# OFFICIAL NOTIFICATION OF DECISION

Project# PR-2021-005745
Application#
SD-2024-000141 FINAL PLAT

A-1-A-2, MESA DEL SOL INNOVATION PARK zoned PC, located on DIEBENKORN between DEKOONING and STRYKER containing approximately 31.8 acre(s). (R-15, S-15)

**FINAL PLAT OF
MONTAGE UNIT 5
TRACT A-1-A-2
OF
MESA DEL SOL
INNOVATION PARK**

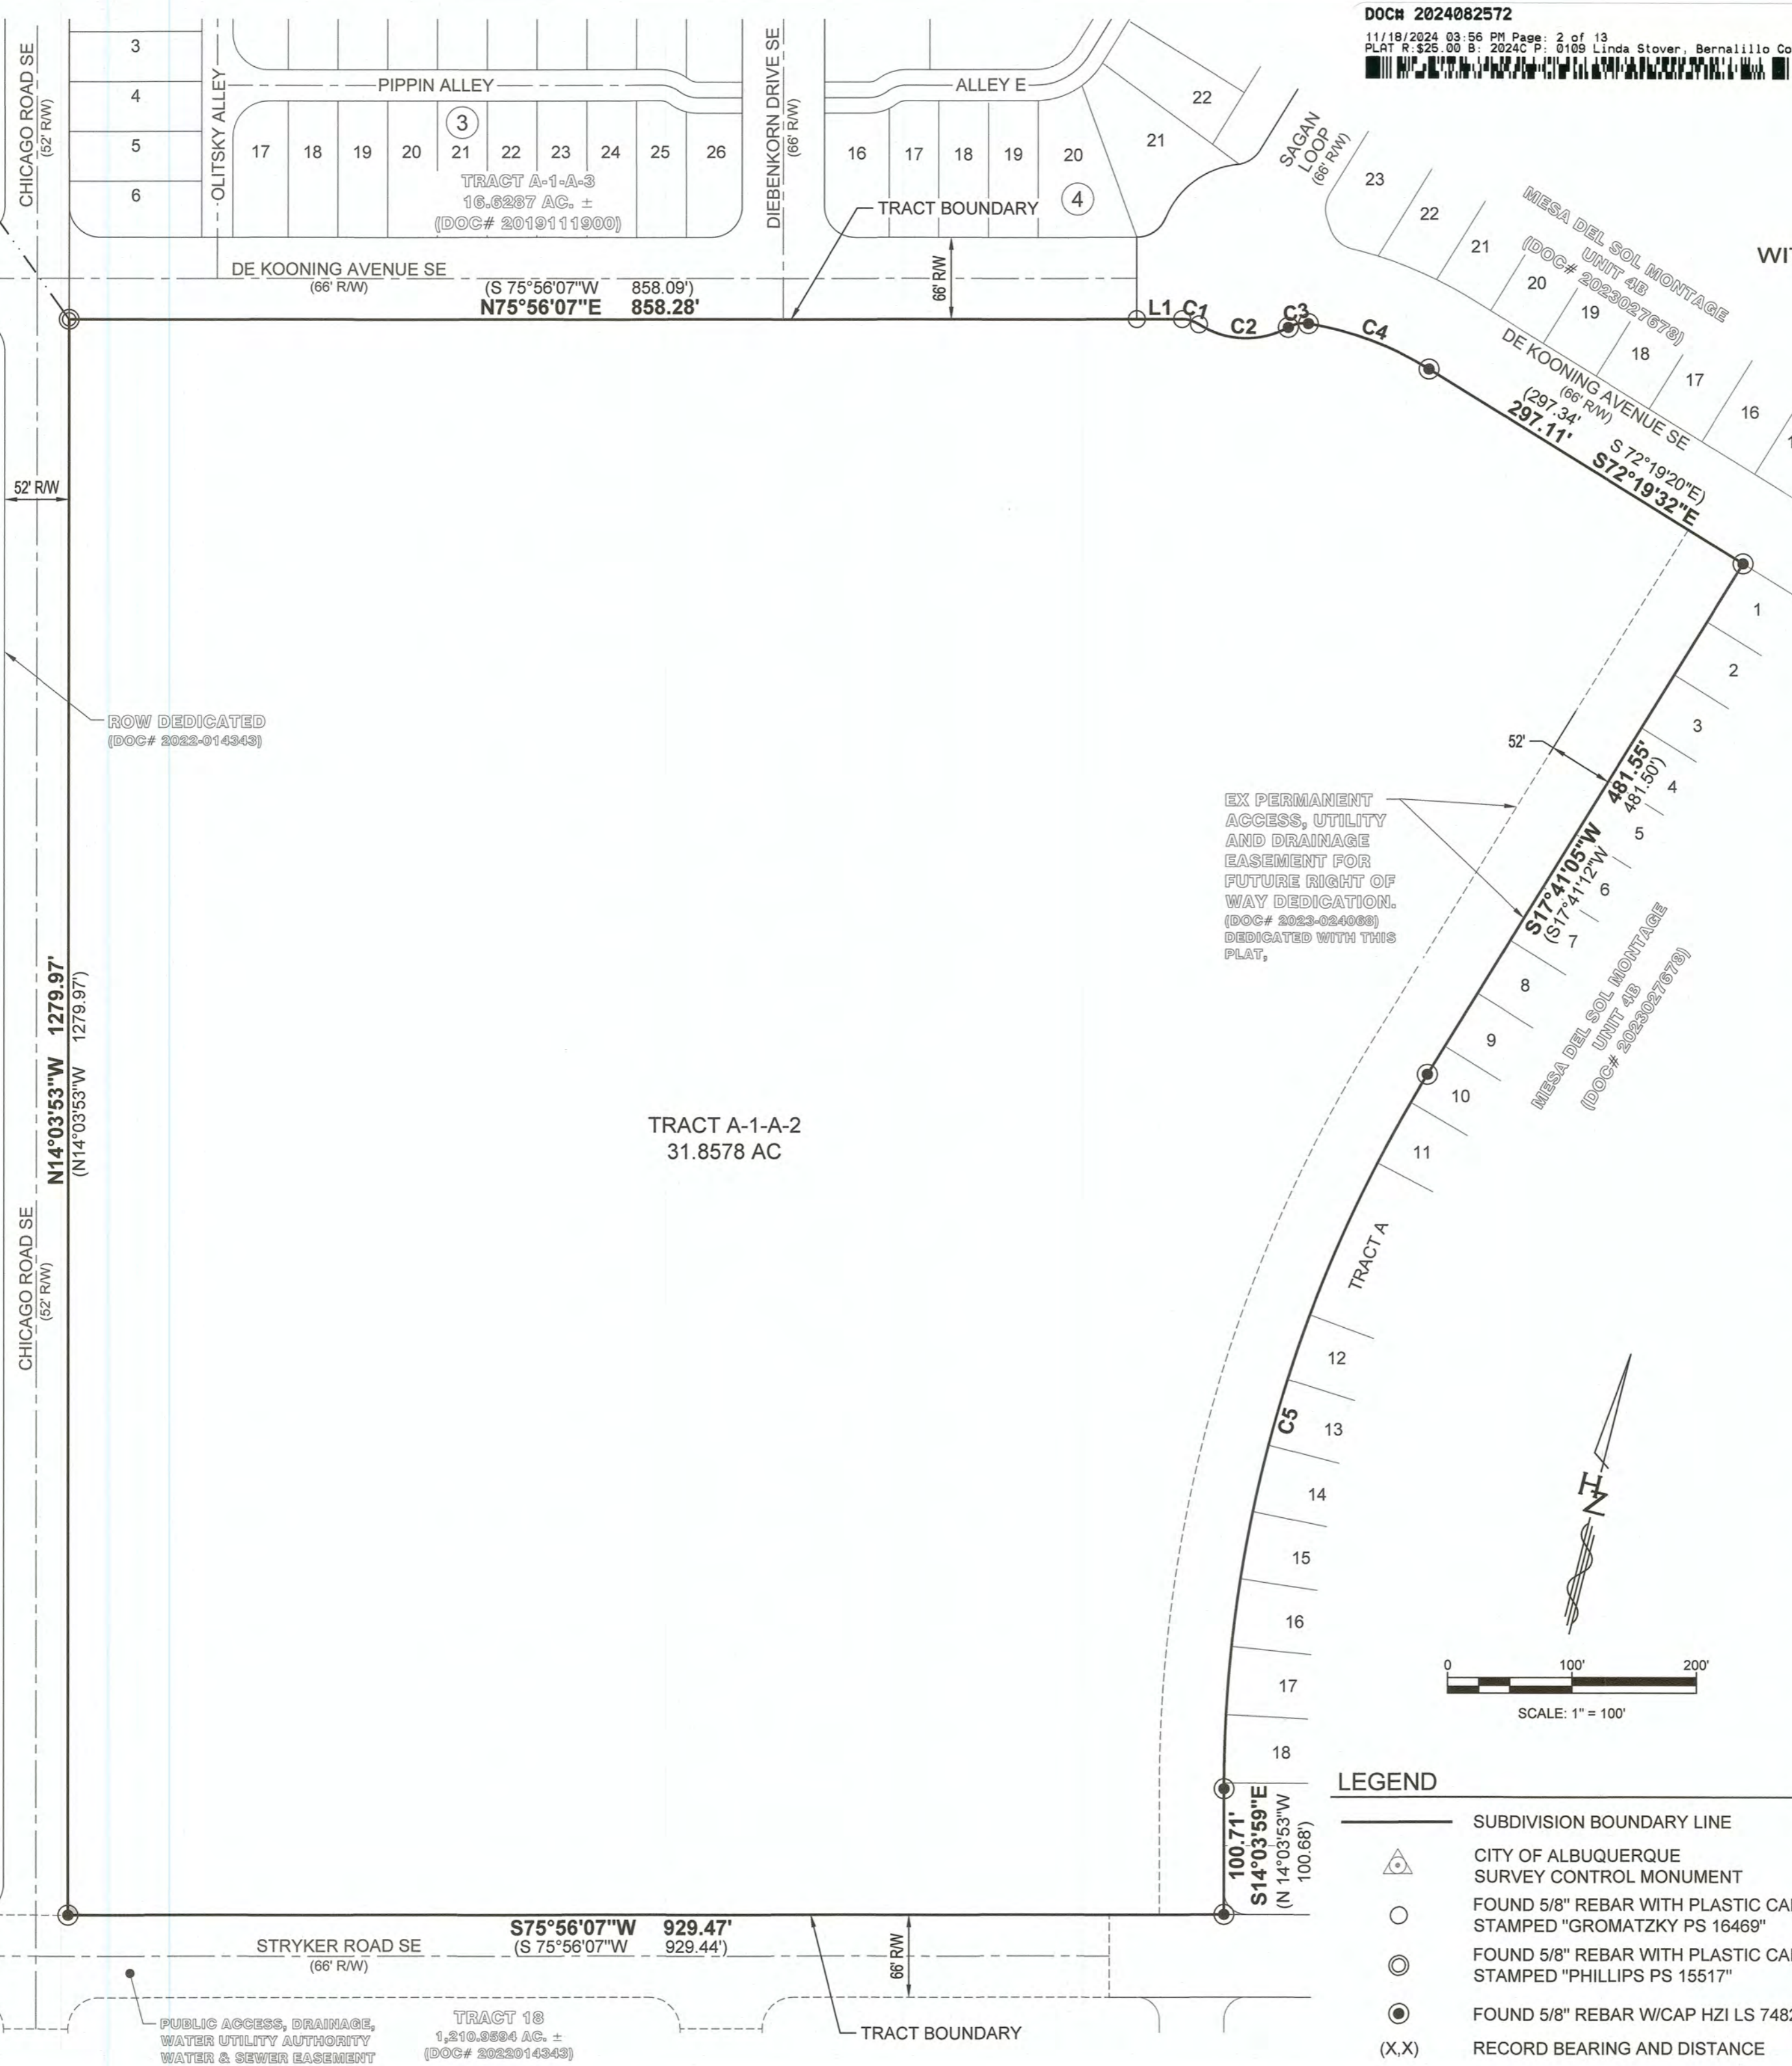
- Addition of language to call out public water and public sanitary sewer easements granted to the Water Authority.
- Add the following note to the plat: "ABCWUA Public Water & Sanitary Sewer Easements Albuquerque Bernalillo County Water Utility Authority (ABCWUA) is granted easement(s) in the dimensions noted on this plat for the construction, installation, maintenance, repair, modification, replacement and operation of public water and sanitary service lines, equipment and facilities reasonably necessary to provide service together with free access on and over the easement and the right to remove trees, shrubs, undergrowth and any other obstacles, modifications, or structures which interfere with use of the easement."

- The Project and Application numbers must be added to the Plat.
- A copy of the AGIS-approved DXF file must be submitted.
- Per 6-6(L)(2)(d)(7) of the IDO, the date of the DHO approval shall be recorded on the Plat.
